From: [REDACTED]
To: [Cleve Hill Solar Park](#)
Subject: Open Floor meeting text
Date: 01 August 2019 16:06:26
Attachments: [REDACTED]

I attach the text of the oral representation given by myself at the Cleve Hill Examination Open Floor Meeting on 22nd July 2019.

FAS Results: Marsh Harrier - Breeding Season
Figure A9.34

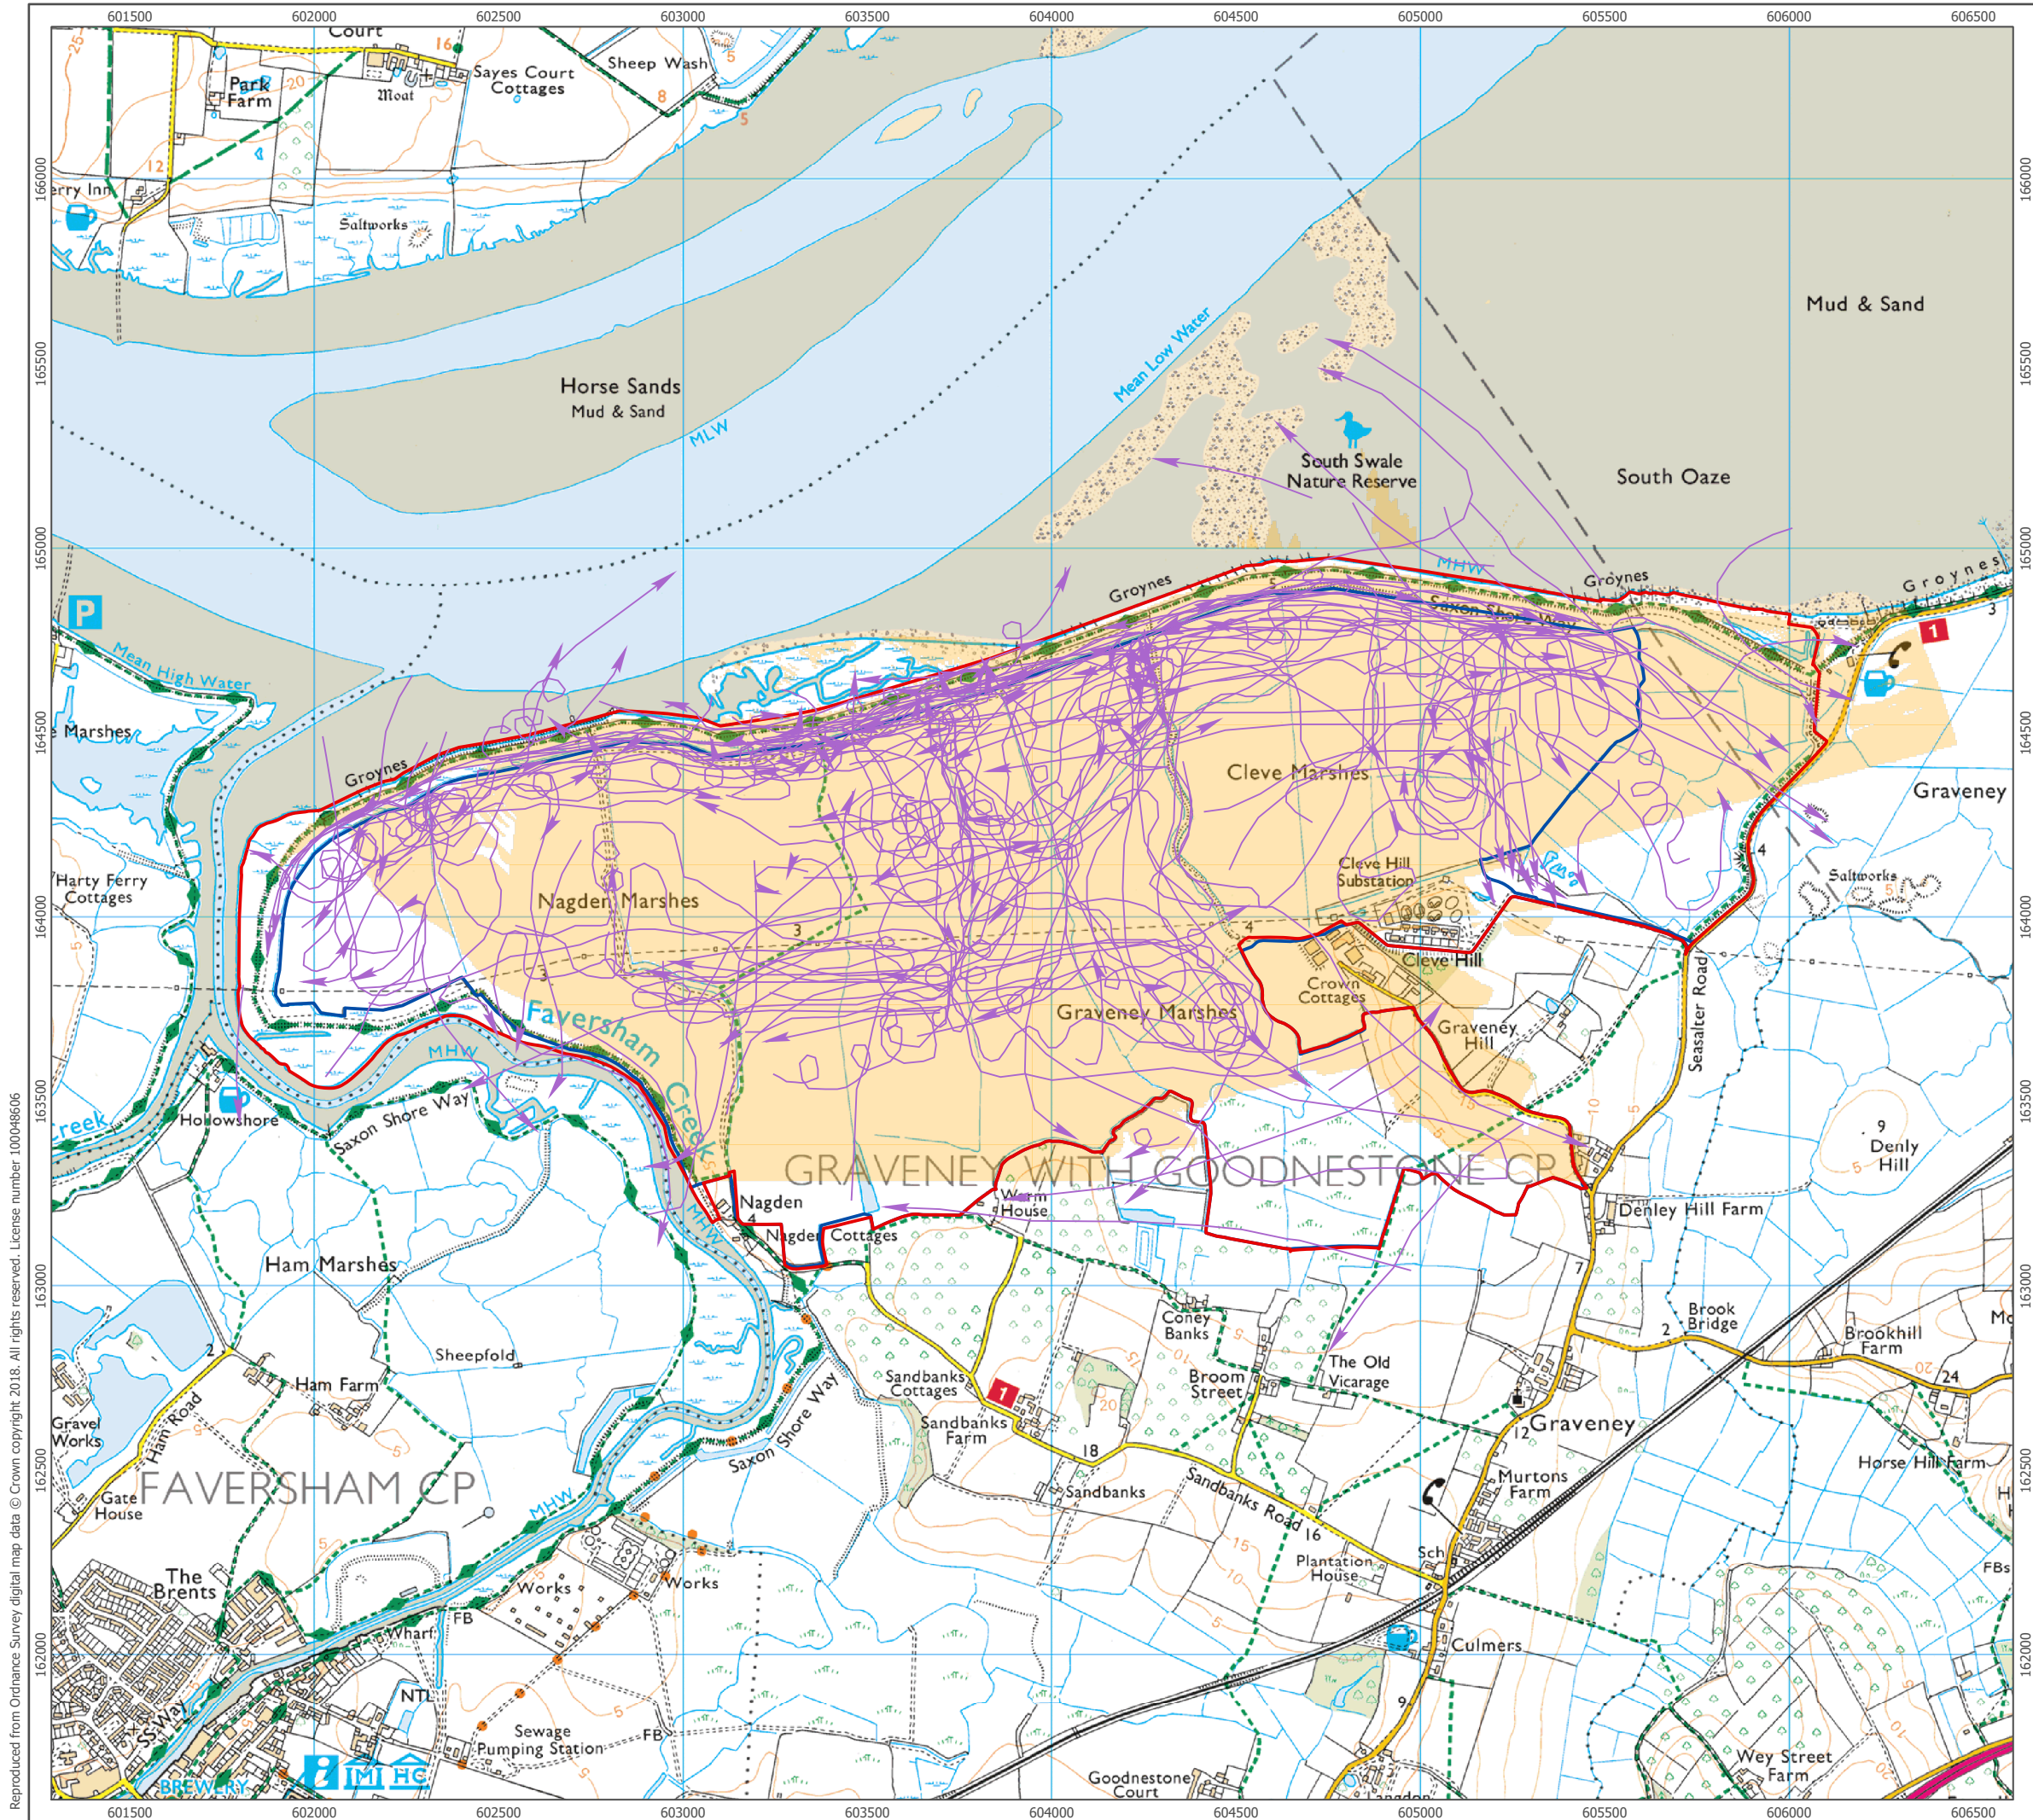
Marsh Harriers are wide ranging birds of open countryside, to some extent opportunistic feeders taking a wider spectrum of prey. Whilst I accept the flightline data in the applicants Environmental Statement showing a preponderance of hunting along the northern borrowdyke it also shows that birds fly frequently over the arable fields. There is, however, no data showing to what extent the arable contributes to food provisioning during both within and outside the breeding season. (This is too time consuming to carry out during a general breeding bird survey). Studies on Sheppey and in East Anglia demonstrate that arable fields are a significant food resource for harriers in the latter part of the nesting cycle This is especially so when they are provisioning large young in the nest, when birds take larger items of prey, game birds and on Sheppey Lagomorphs, hairs and rabbits; passerines such skylarks and starlings also feature in the diet.

The land is thus functionally linked to the Special Protection Area in respect to Harrier species and in my opinion the proposed development site is critical for maintenance the local Swale population of marsh harriers.

The ES refers to birds being able to hunt along the ditch corridors that have been increased from their original 5 metre width alongside ditches to 15 metres. When hunting marsh harriers quarter the land

in broad wavering lateral sweeps. Post construction, marsh harriers will be presented with narrow flightlines (in the context of the large scale development) where their vision will be impeded by the supporting structures and panels, well within the height of the marsh harriers foraging height of < 10 metres.
